Your Ref: OWQC22121
Our Ref: BR/49/19/OUT
Please ask for:
Mr S Davis

Outline application with all matters reserved for 22 No. new dwellings consisting of 2 No. 1 bed dwellings, 18 No. 2 bed dwellings & 2 No. 3 bed dwellings.
26 Burnham Avenue Bognor Regis

OBJECTION Members unanimously AGREED to OBJECT to Planning Application BR/49/19/OUT on the following grounds: -

Streetscape (Proposed) 1:100
0 2.5 5.0 M

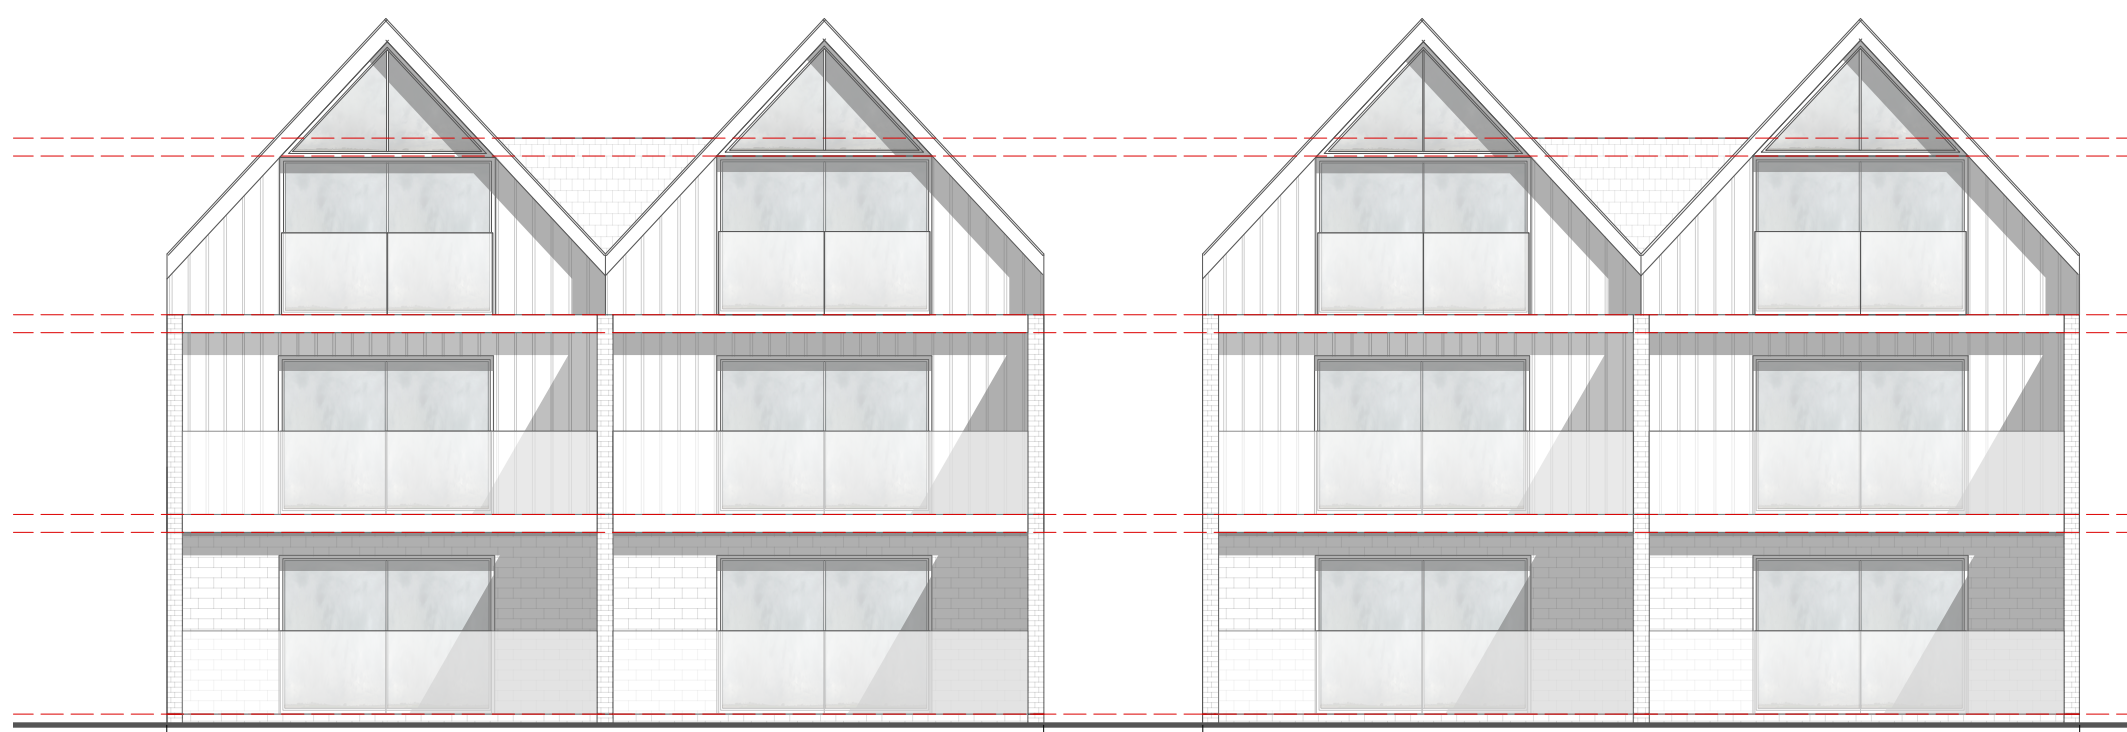
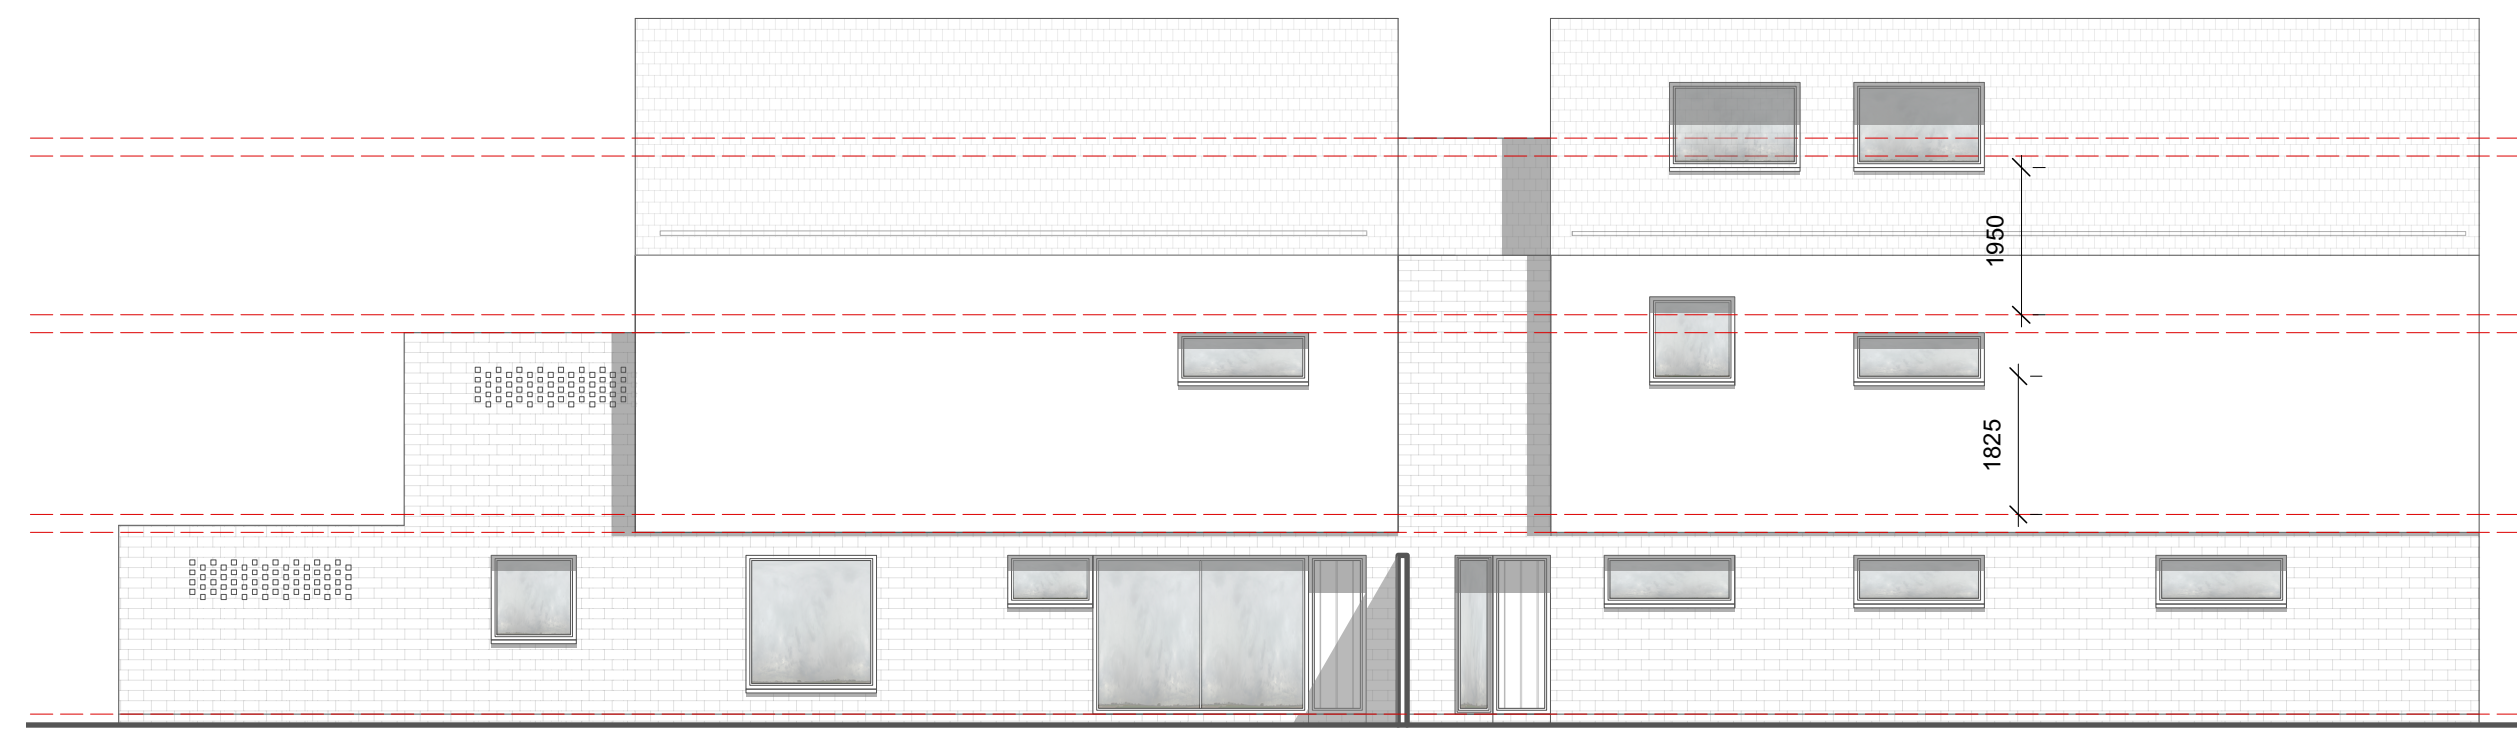
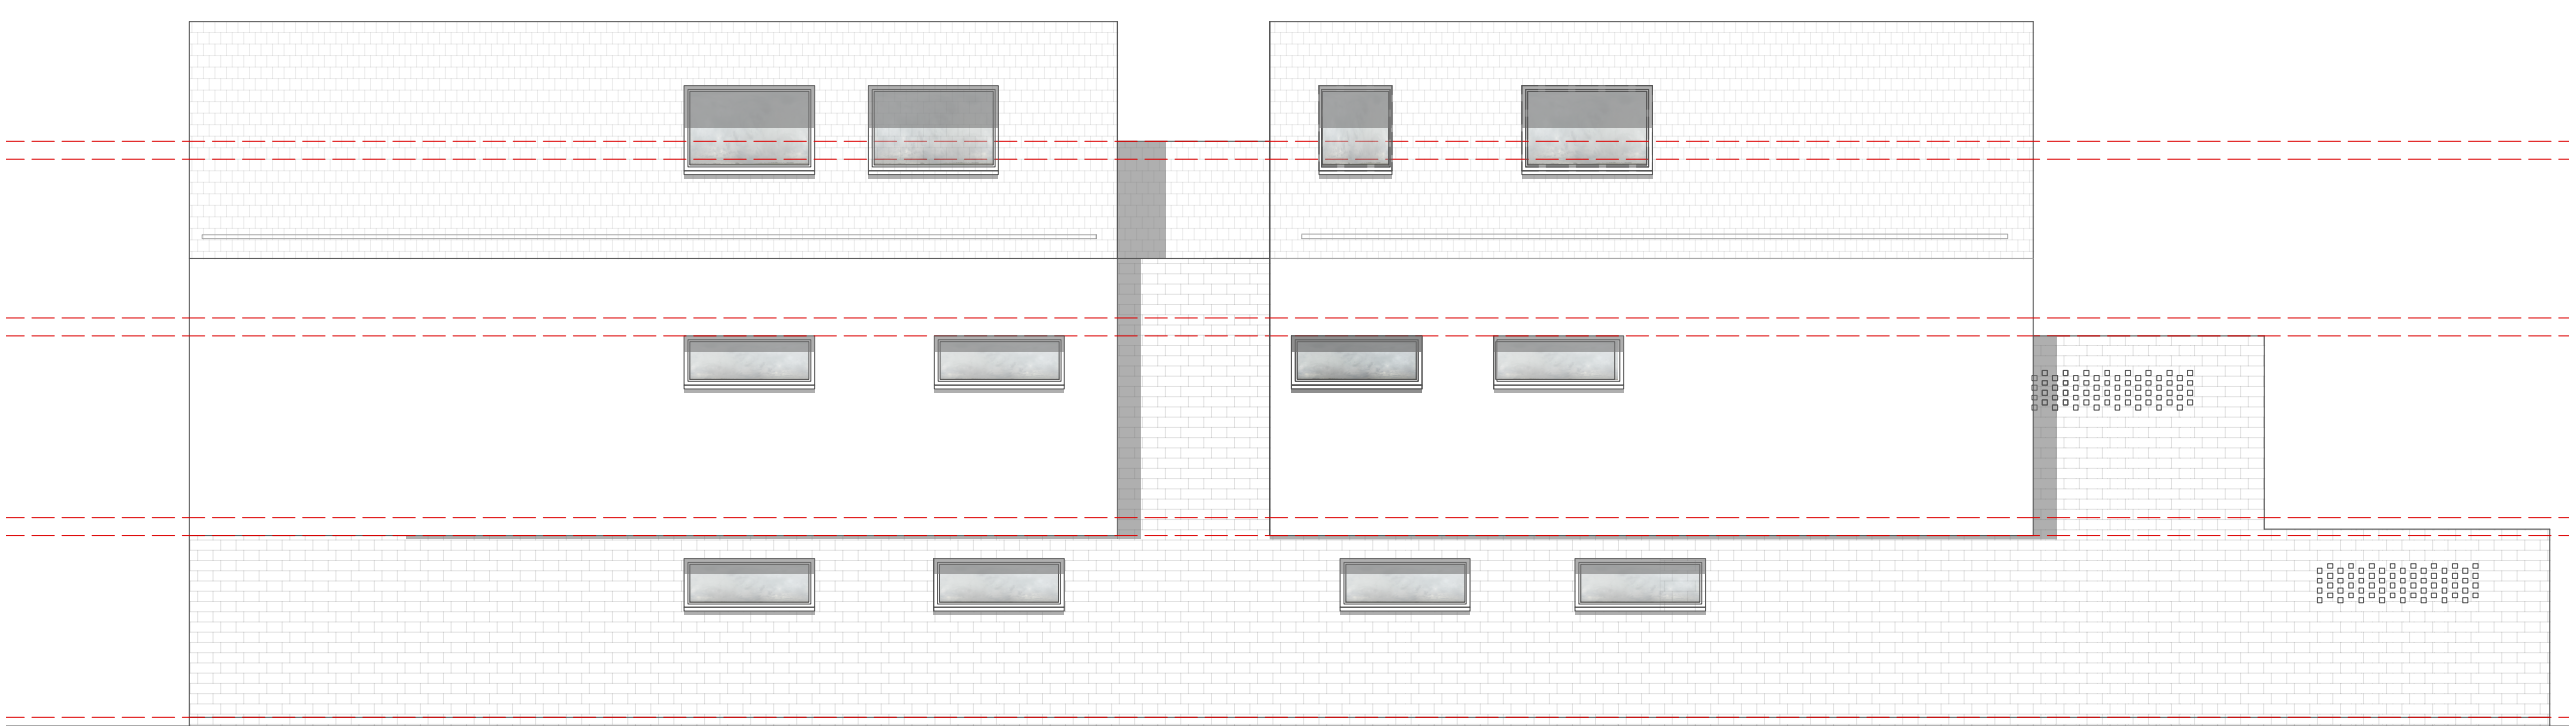
Policy D SP1 of the Arun Local Plan 2011-2031 stipulates that the design should reflect the characteristics of the site and local area. Members were of the opinion that these proposals do not meet this criteria and show a lack of sensitive understanding of the site/context and does not respond to locally distinctive patterns of development. The scale of the proposed development detracts from the local and wider area's character and is not within the general confines of the overall character. The proposed dwellings would, by virtue of its layout, siting and size, result in an overdevelopment of the site and have an overbearing impact on the neighbouring properties.
